Recommendation Report for Planning Permission for Works or Extension to a Dwelling

REF NO: P/94/19/HH

LOCATION: 28 Harbour Road
Pagham
PO21 4TG

PROPOSAL: Single storey front extension

PROPOSED G.F. PLAN.
[1:50]

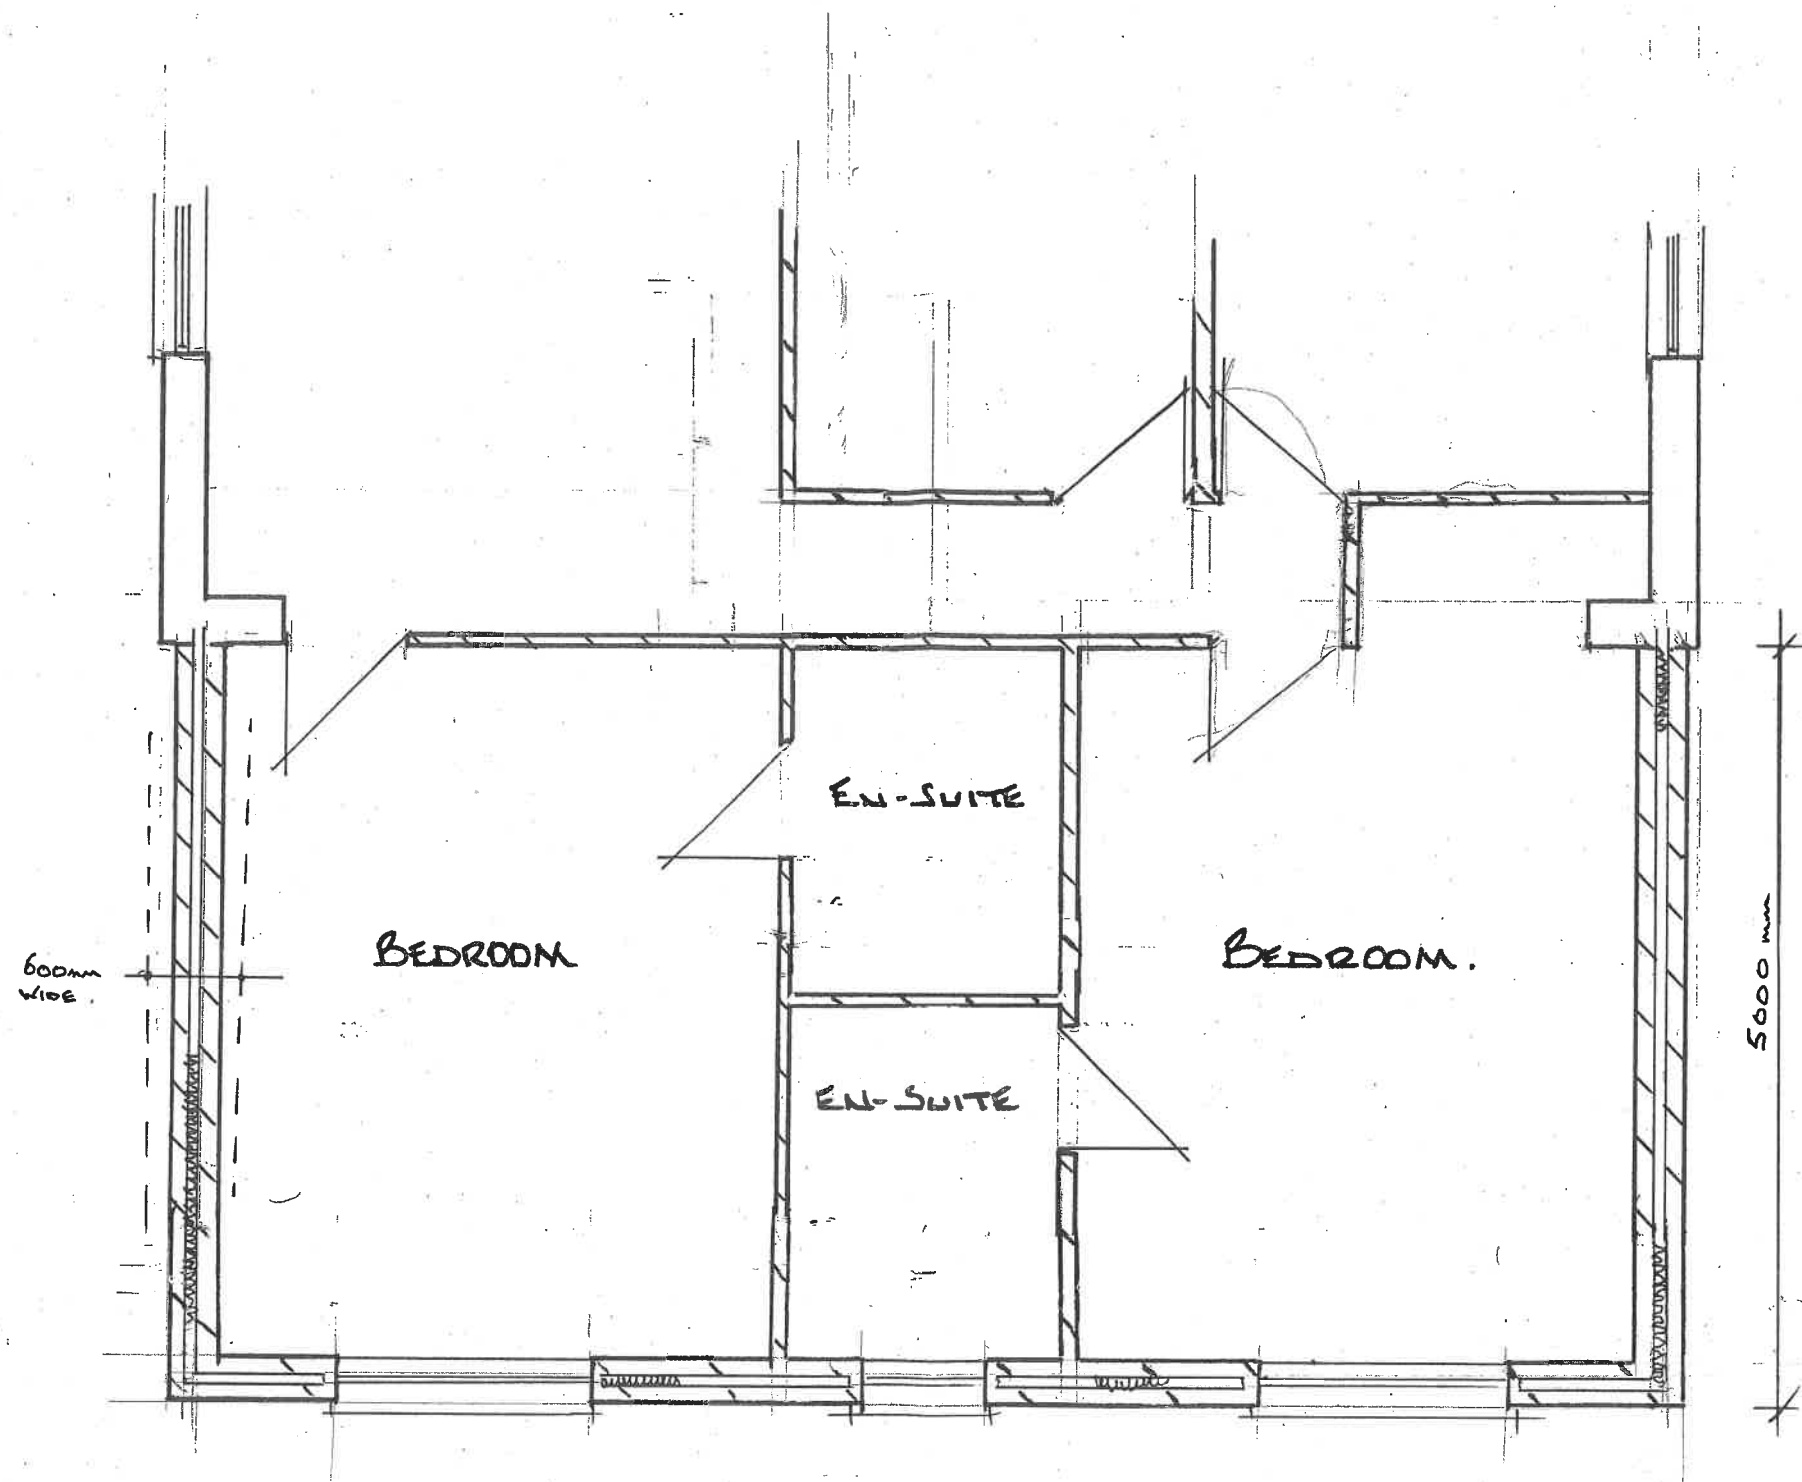
The proposed extension will have a depth of 5m. This will extend beyond the properties to the east and west however this is only minor and due to the siting of the properties, it is not considered the development extends beyond the established line of development.

There are to be 3 windows on the front of the proposal due to its siting, of the existing dwelling and the addition is not considered to result in additional adverse impacts. The proposed windows are not considered to overlook as they only have views the front garden of the host dwelling and a window to the front is replacing existing. The proposal is deemed to accord with D DM1 and D DM4 of the Arun Local Plan.

EXISTING ELEVATIONS

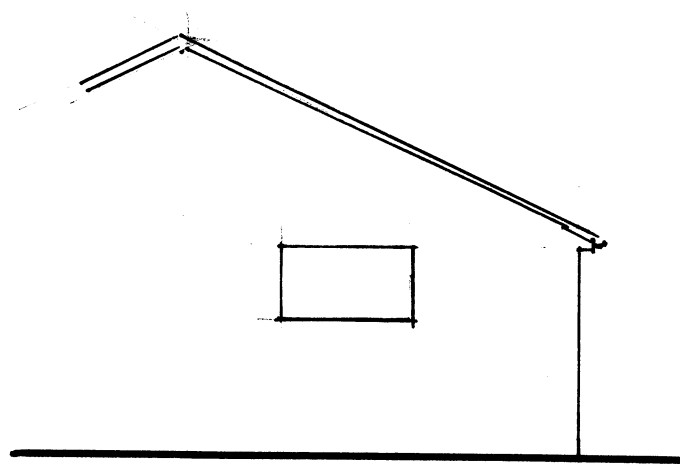
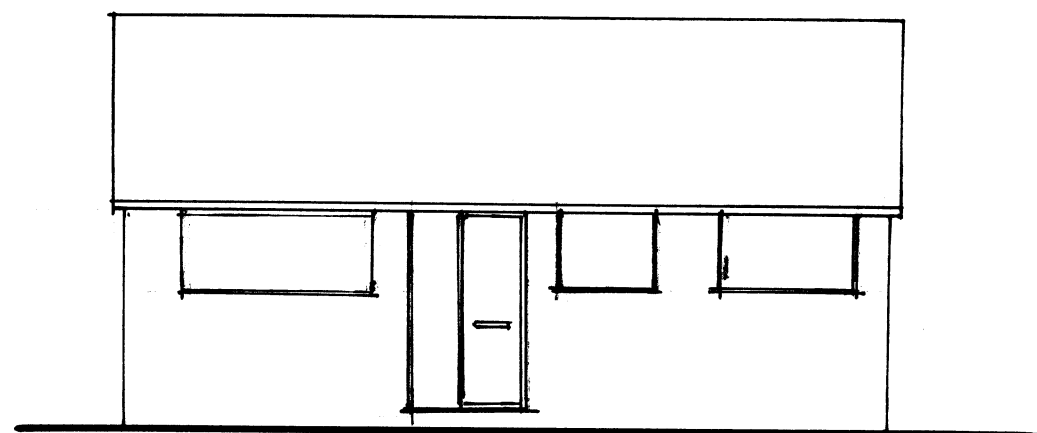
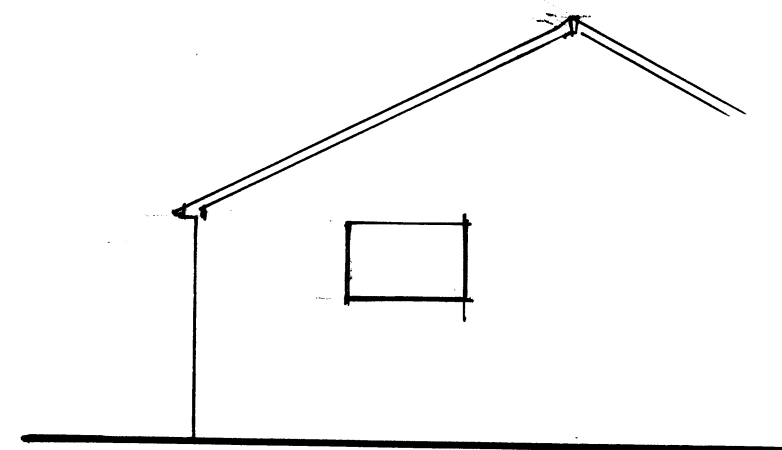
The surrounding properties are varied in design and style and the materials will match that of the existing dwelling which helps to ensure that it appears subservient and well integrated with the host dwelling.

The extension will have a flat roof height of 3.5m with an eaves height of 2.7m to match that of the existing dwelling. Due to the scale and location of the development is not considered to appear adversely overbearing or overshadowing upon the neighbouring properties at No.30 and No.26.
